Subject: RE: Request for further information A/138/21/L

Please can you also confirm acceptance of the description: Listed building consent for repositioning of the Golf Clubs main Bar and repositioning of modern timber stud wall to Snooker Room, exposure of fireplace and door opening works and the sealing up of 2 doors (former bar door opening & former door opening into the bar seating area).

J O B	CHECKED
	LRA
Ham Manor Golf Club West Dr Angmering, Littlehampton BN16 4JE	DRAWN
	ES
CLIENT	DATE
	21.06.16
Ham Manor Golf Club	SCALE
	1:1250 @ A1
DRAWING	REVISION
	.
Site / Block Plan	NUMBER
	7133/001

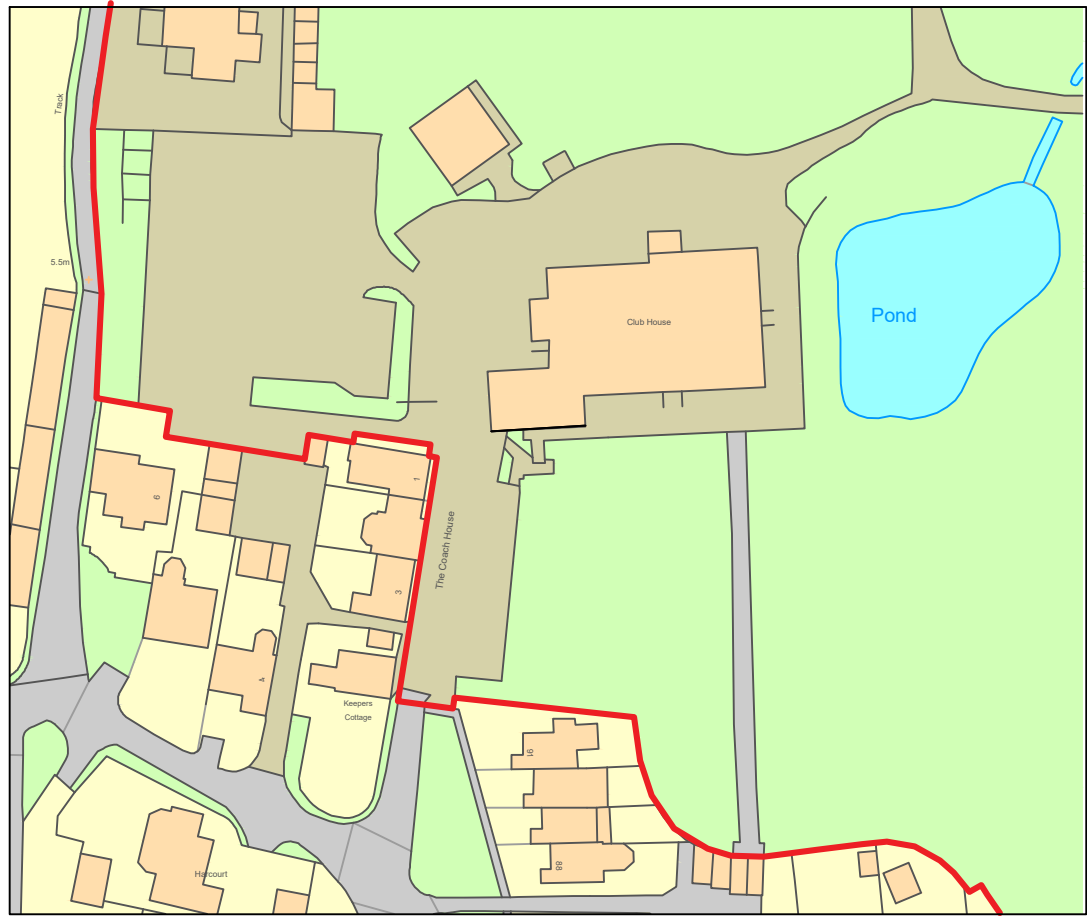
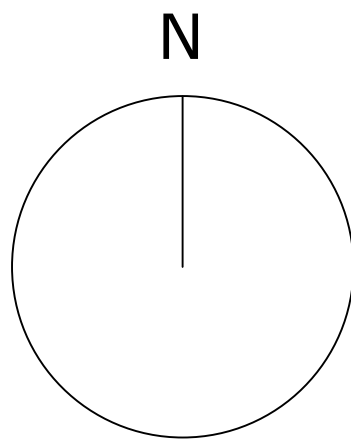
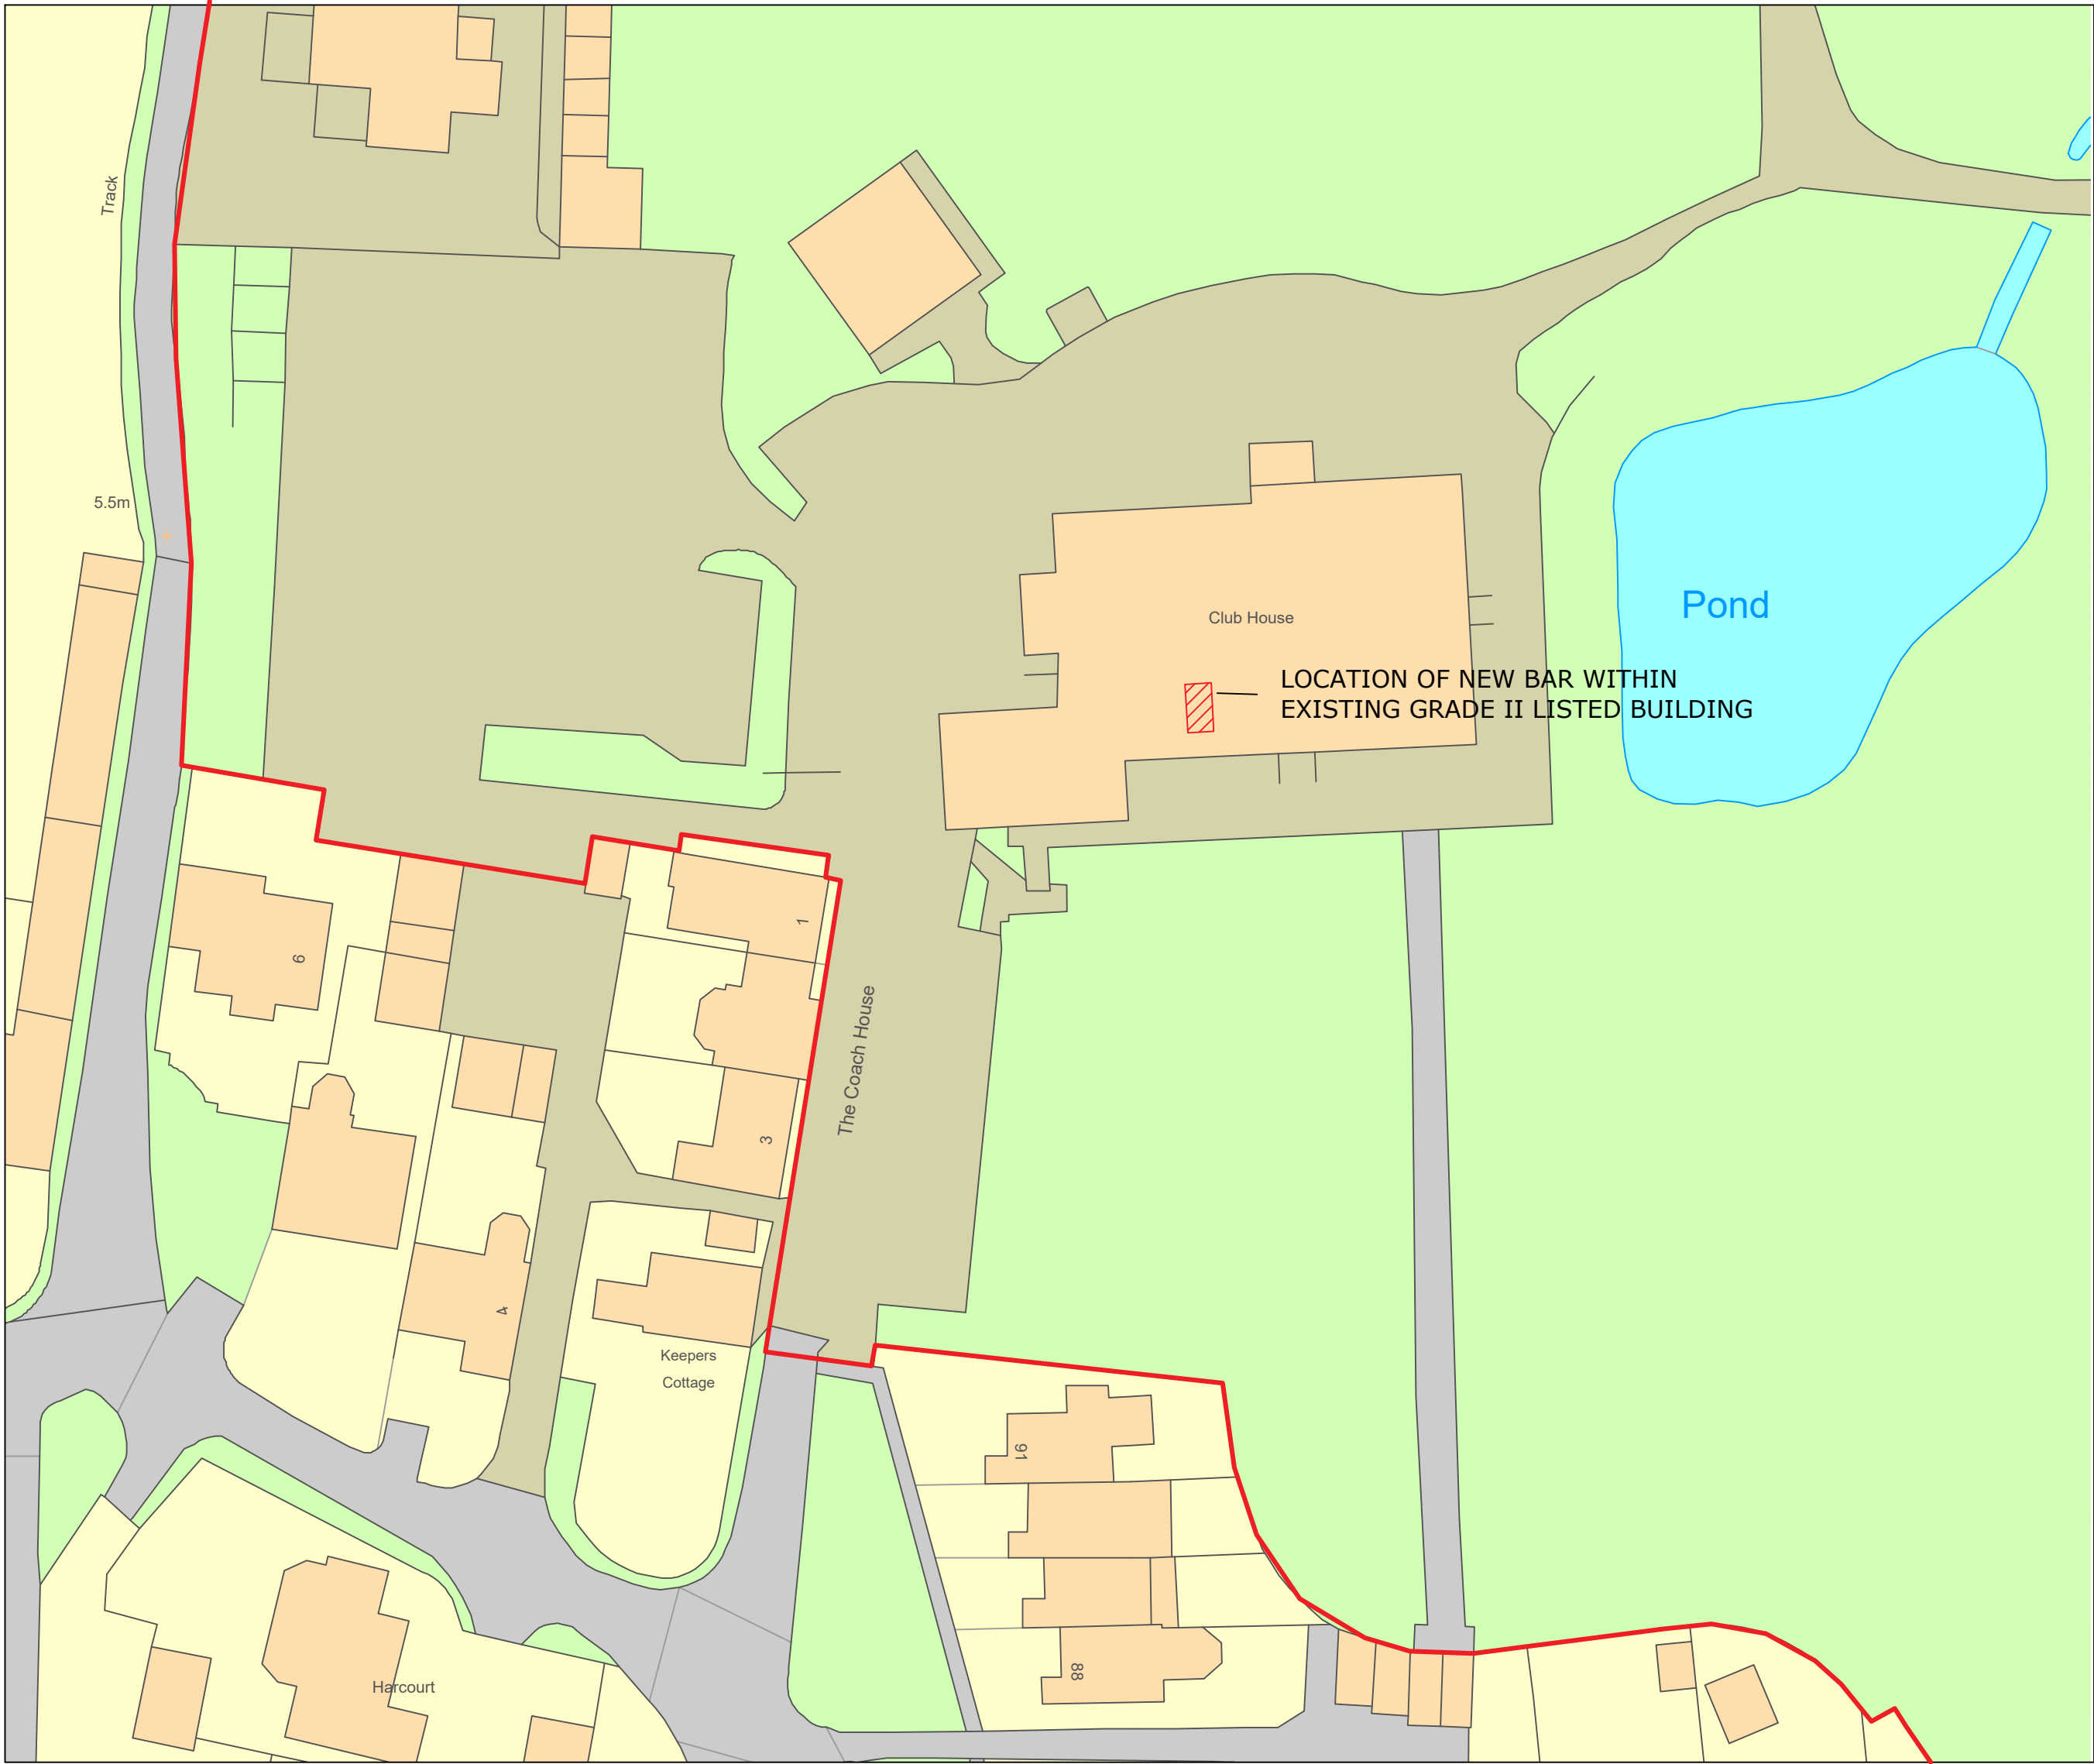
Further to our telephone conversation earlier today. Please remove the layers from the submitted location plan and re submit at a scale that shows the application site.

With reference to your email below, it is a Validation requirement that the red edge on the Location Plan shows the whole application site. If you are unable to show the site at 1:2500 you can submit at a different scale in order to show the complete red edge.

Thank you for your email, in order to show the full extent of site ownership for the Golf Club, I have now prepared a 1:2500 scale drawing with scale bar and Red edge outline showing the full application site.

The application site is Ham Manor Golf Club which is spread of a very large region of land which if shown at 1:2500 would be greater than a number of AO paper sheets in order to correctly illustrate (in addition to the large cost of purchasing such a big amount of OS Map Data)– as such we instead (as has been accepted as valid before in a number of previous applications to local authorities) shown a greater extent aerial view – which has now been update to show full site ownership boundary in RED.

There is no new proposed external development just some small internal alterations within the Grade II Listed building which require regularisation, in order to be of assistance we have now updated the block plan to show the location of the new bar within the existing Grade II listed club house which we trust is acceptable.
